## Addendum 02

Date: September 26, 2011

To: Wright Ryan Construction (Construction Manager)  
From: Ben Walter, CWS Architects  
Regarding: Elm Terrace – Portland, Maine  
Subject: Addendum 02

GRADING AND DRAINAGE PLAN

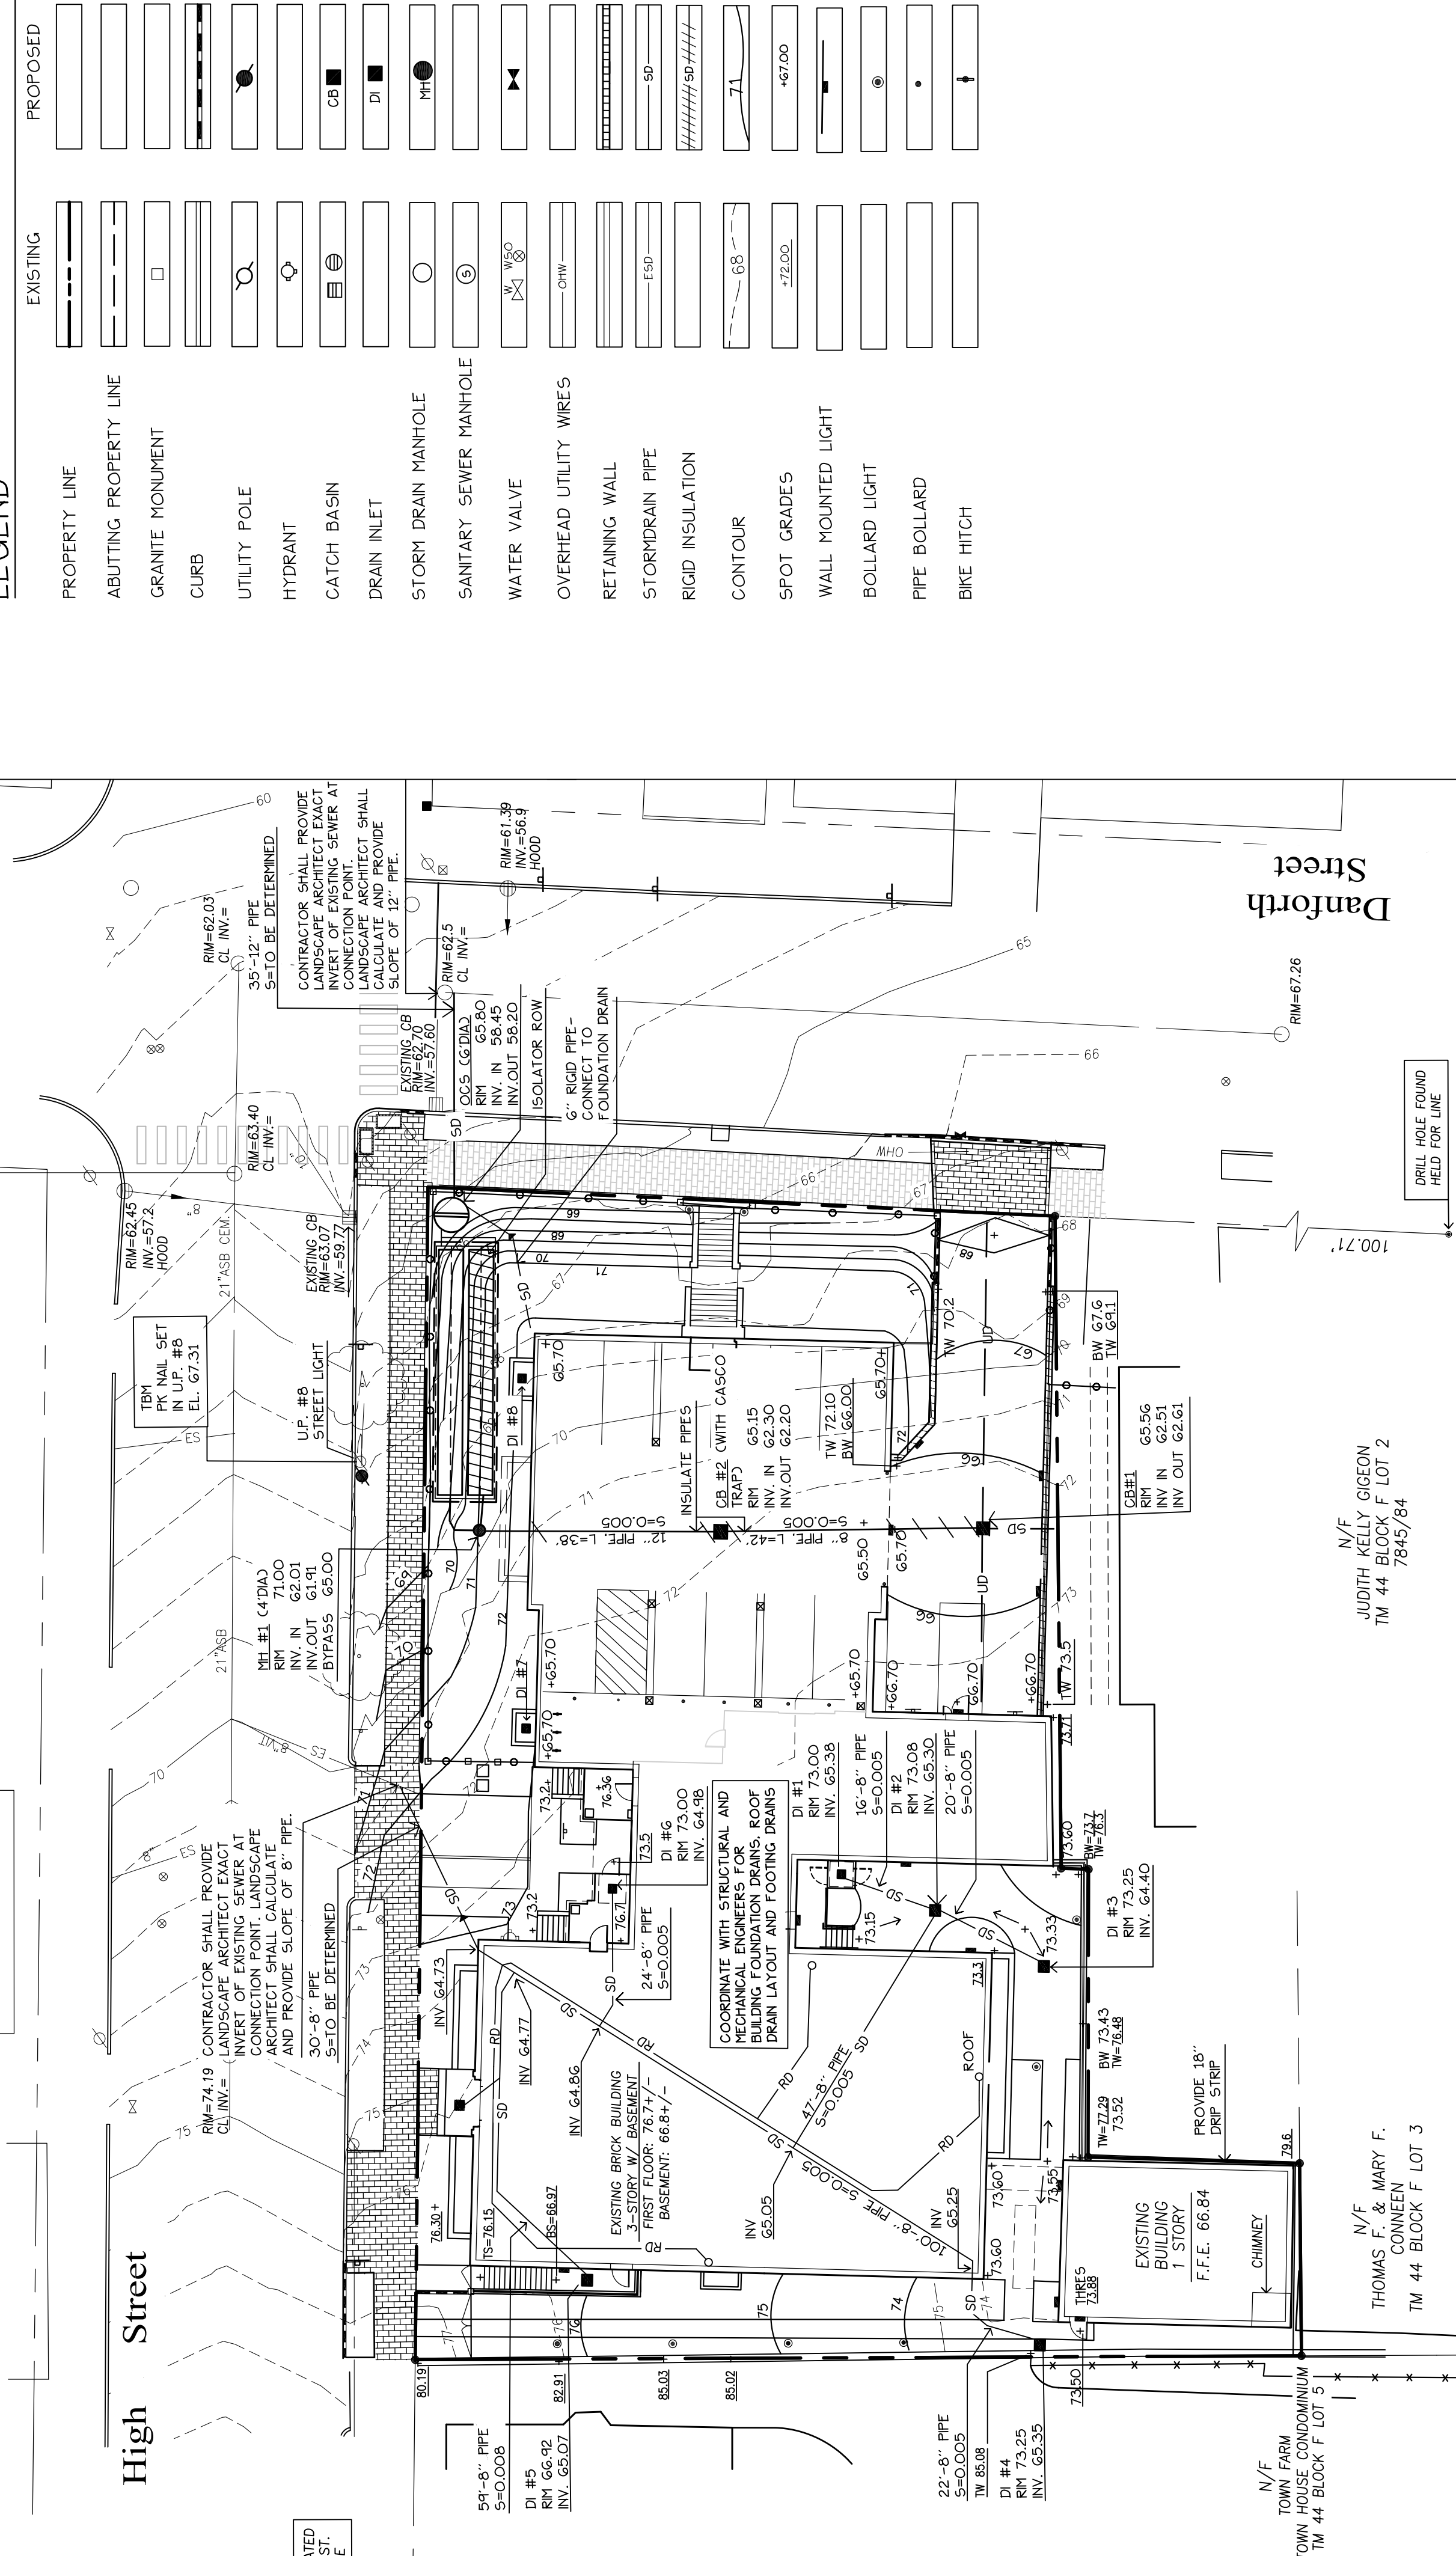
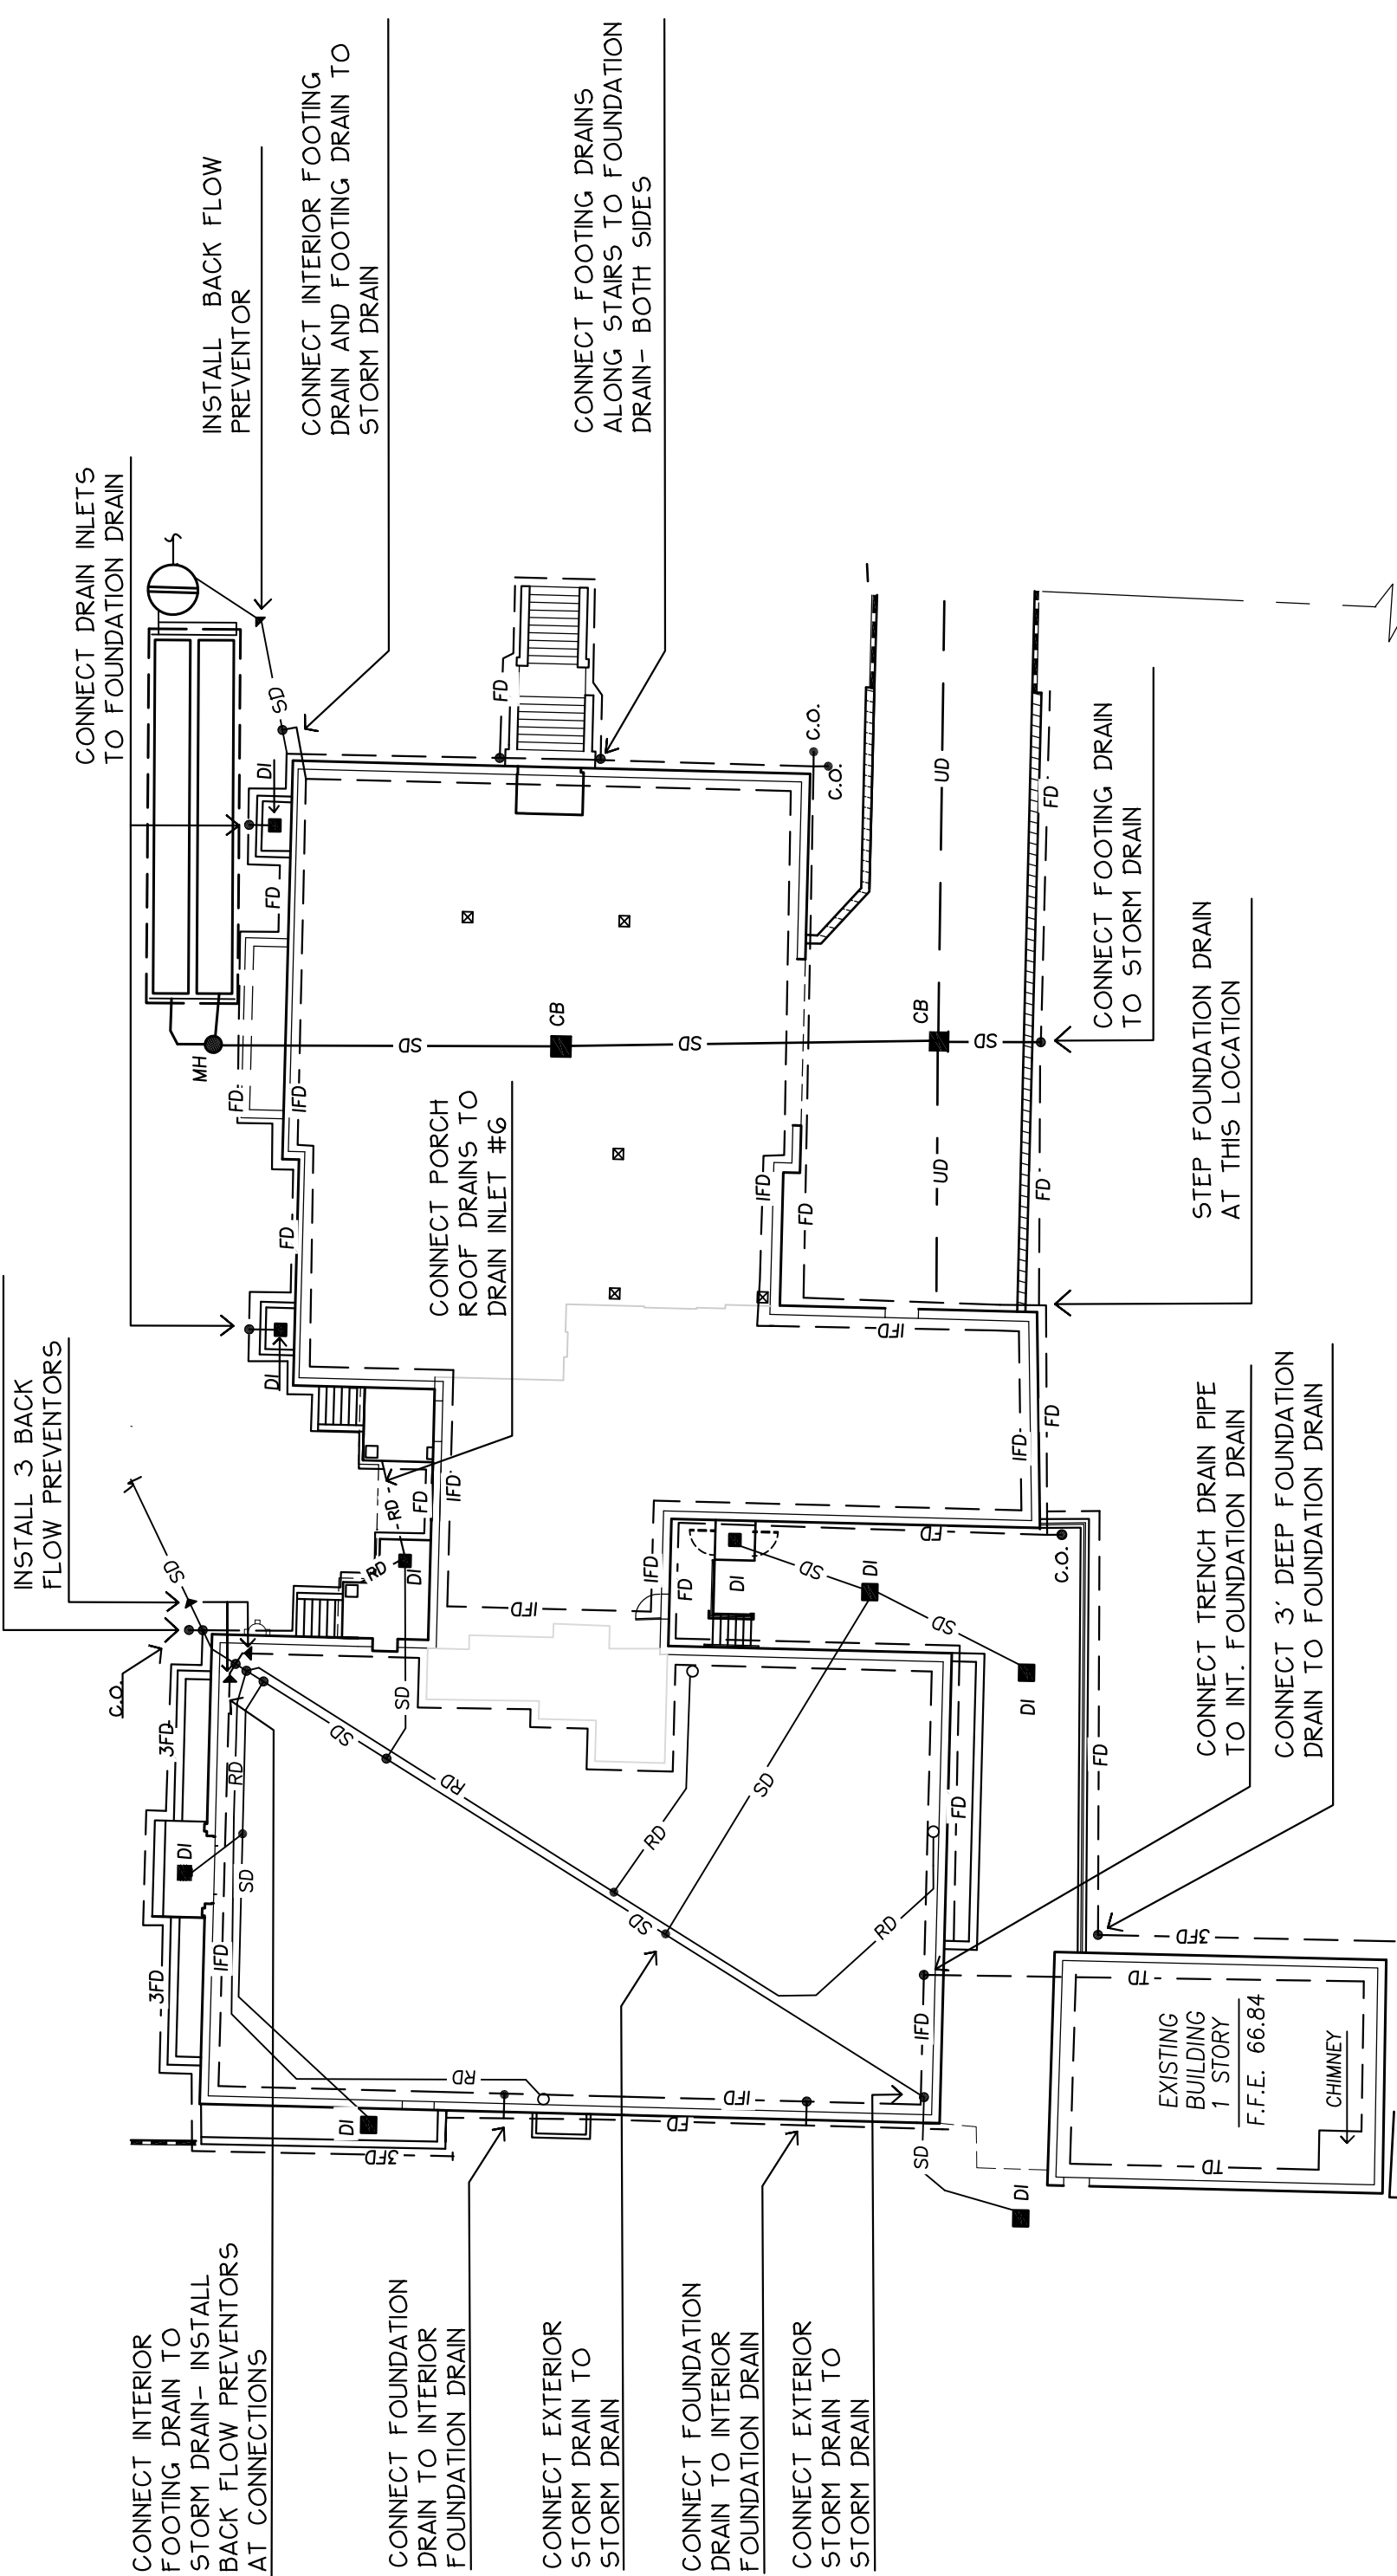
7. Replace Sheet No.: 3 with Sheet No.: 3, revised September 25, 2011. This change coordinates with revisions made in item 21 of Addendum 01 to Drawing M3.0.
